Your ref:	Boots Strand Norman House - A...	<b>Please reply to:</b>	<b>Fraser Fikrie</b>
Our ref:	21/00528/ADV	Tel No:	0753424 7967
		Fee Queries:	0207 641 6500;
		Email:	planningreception@westminster.gov.uk;
Mr Ghazale Borouni Child Graddon Lewis 155 Commercial Street London E1 6BJ		<b>Incomplete Applications</b> Development Planning City of Westminster PO Box 732 Redhill, RH1 9FL	
		1 February 2021

**Address: Norman House, 105-109 Strand, London, WC2R 0AA,**

**Proposal: Display of 2 internally illuminated 'Boots' fascia signs each measuring at 0.4m x 0.78m; 3 internally illuminated category fascia signs reading 'Pharmacy' 0.18m x 1.105m, 'Beauty' 0.18m x 0.75m and 'Wellness' 0.18m x 0.1025m; 1 internally illuminated green sign measuring 0.45 x 0.45m; and 1 internally illuminated projecting sign measuring 0.50m x 0.56m.**

Drawing Title
PROPOSED ADVERTISEMENT
CONSENT ELEVATION AND
PLAN

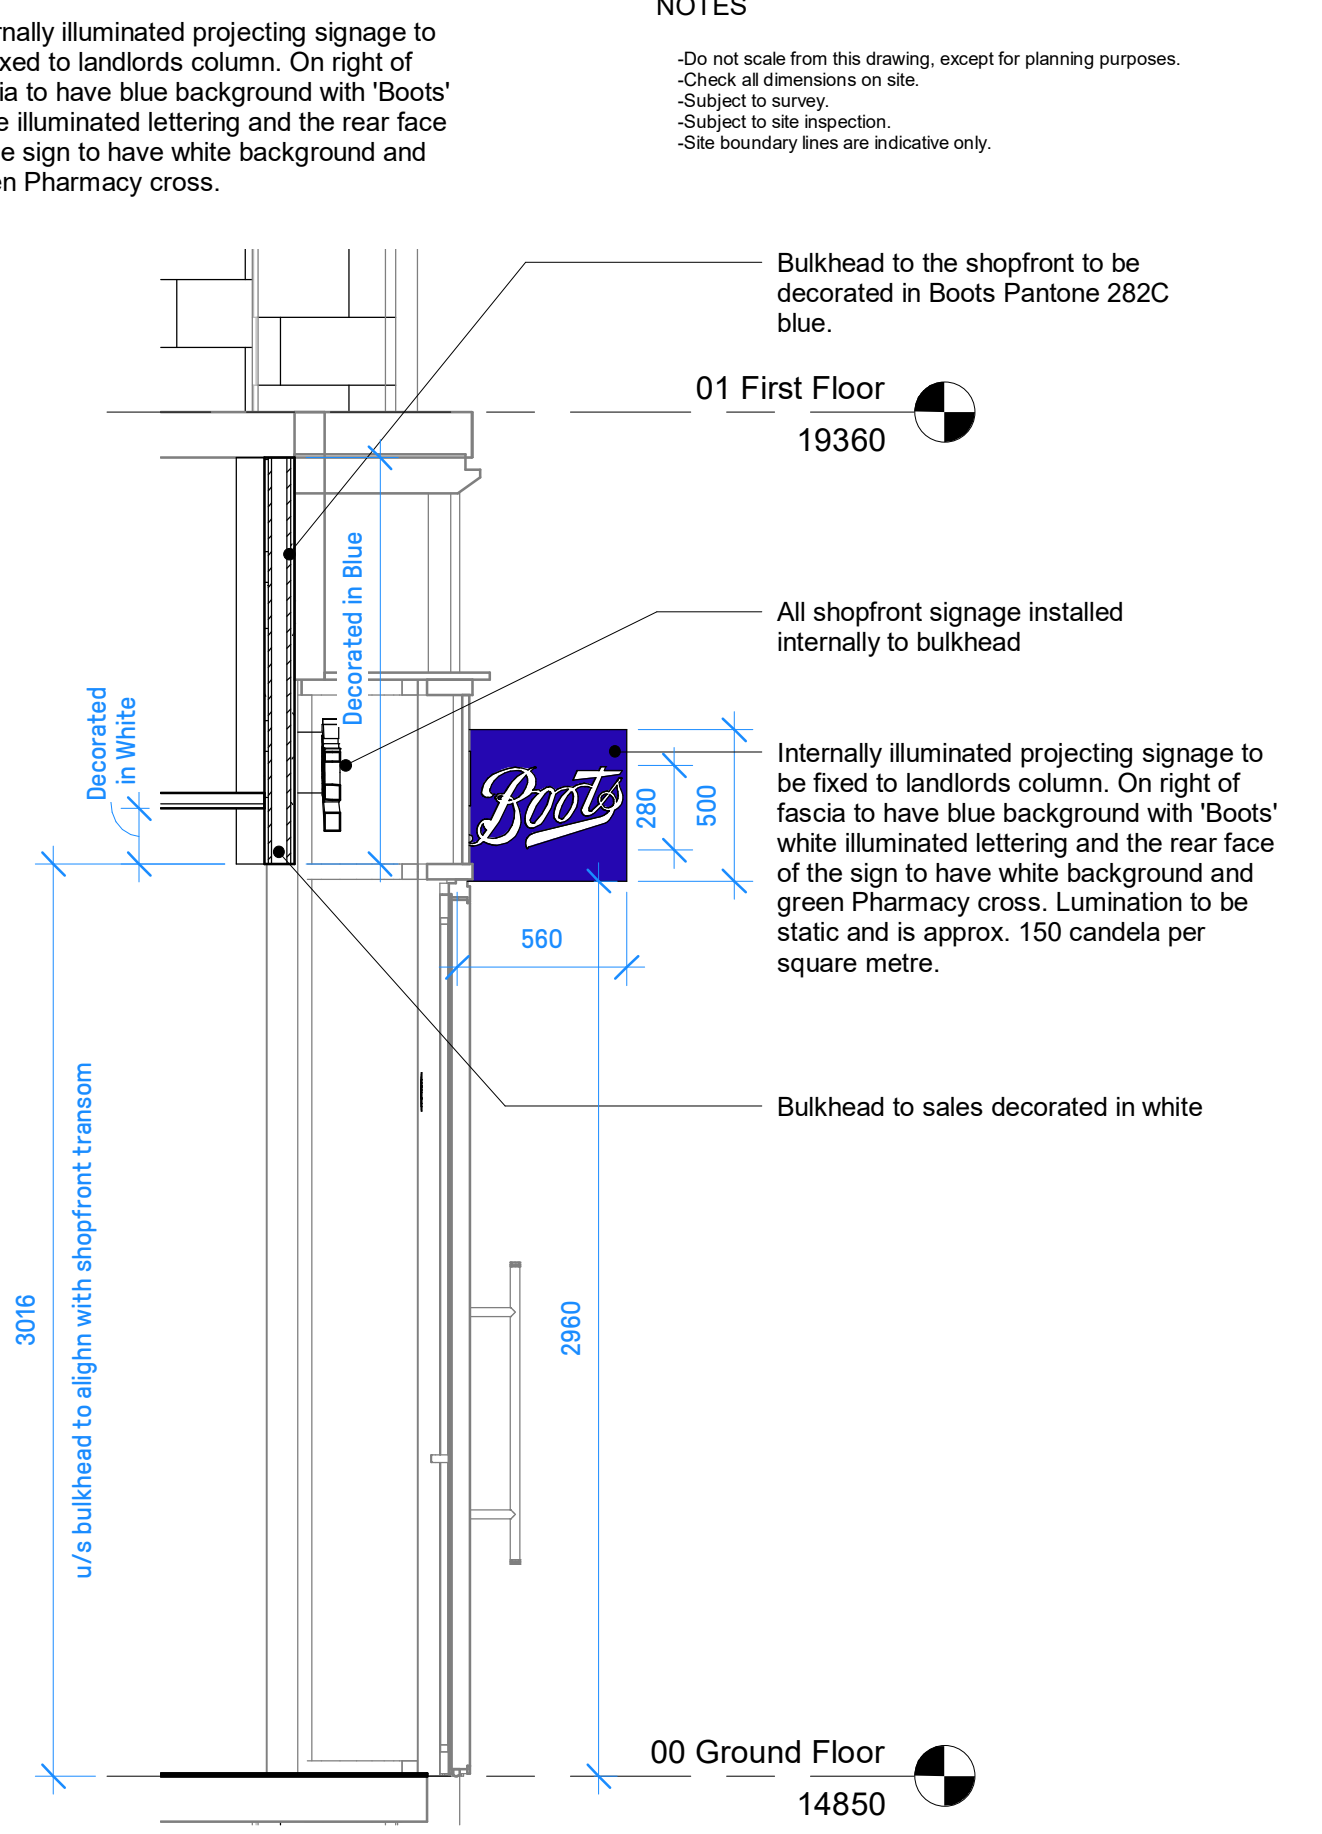
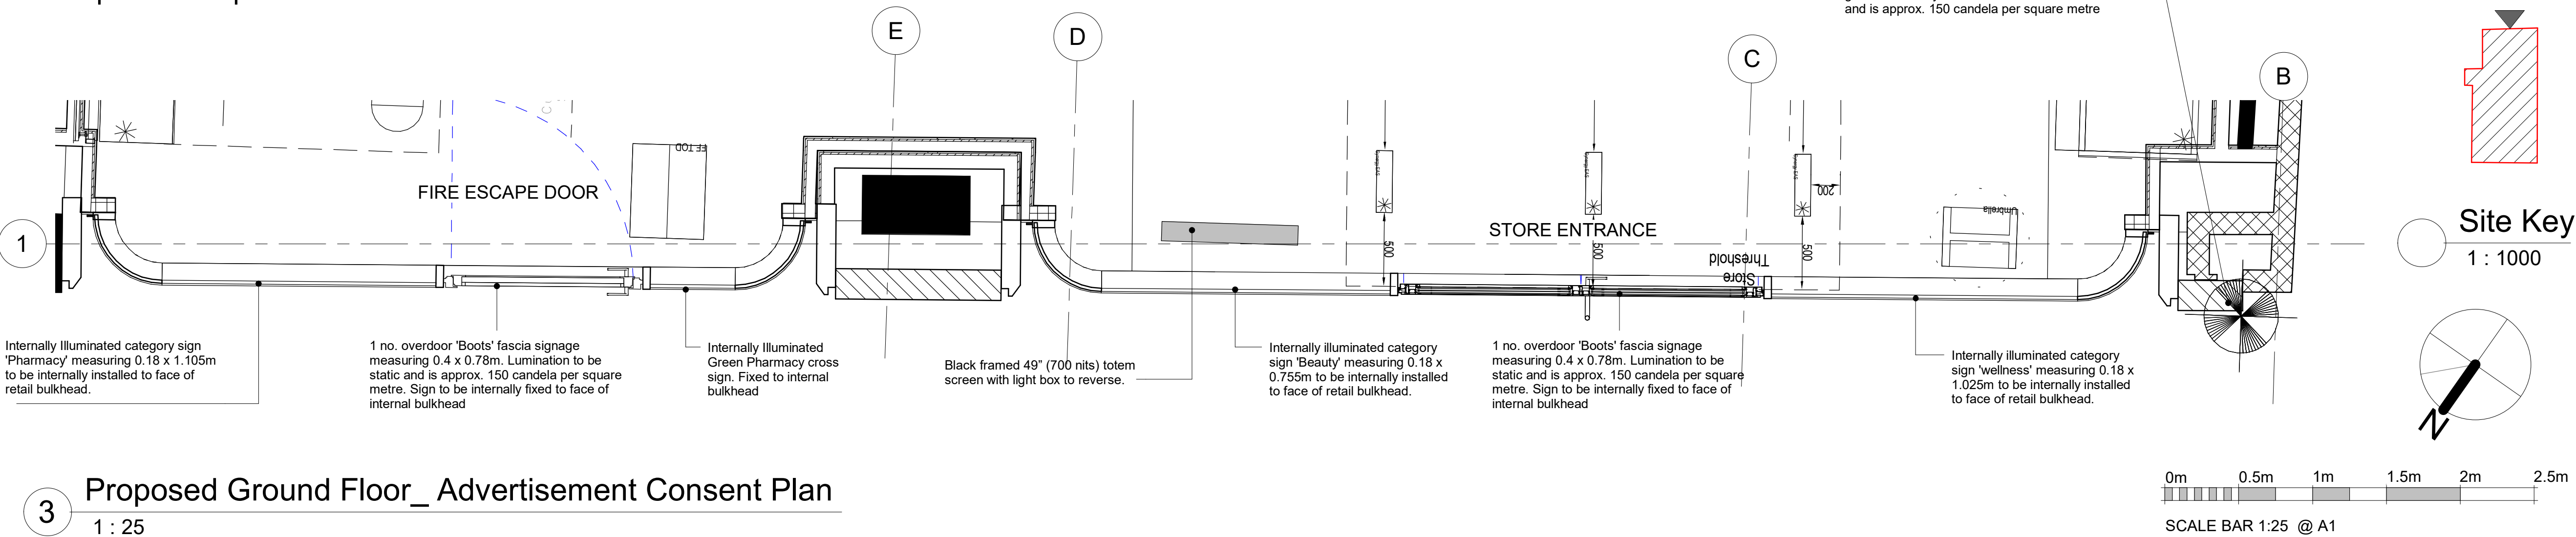
- section through the advertisements to show the method of illumination.
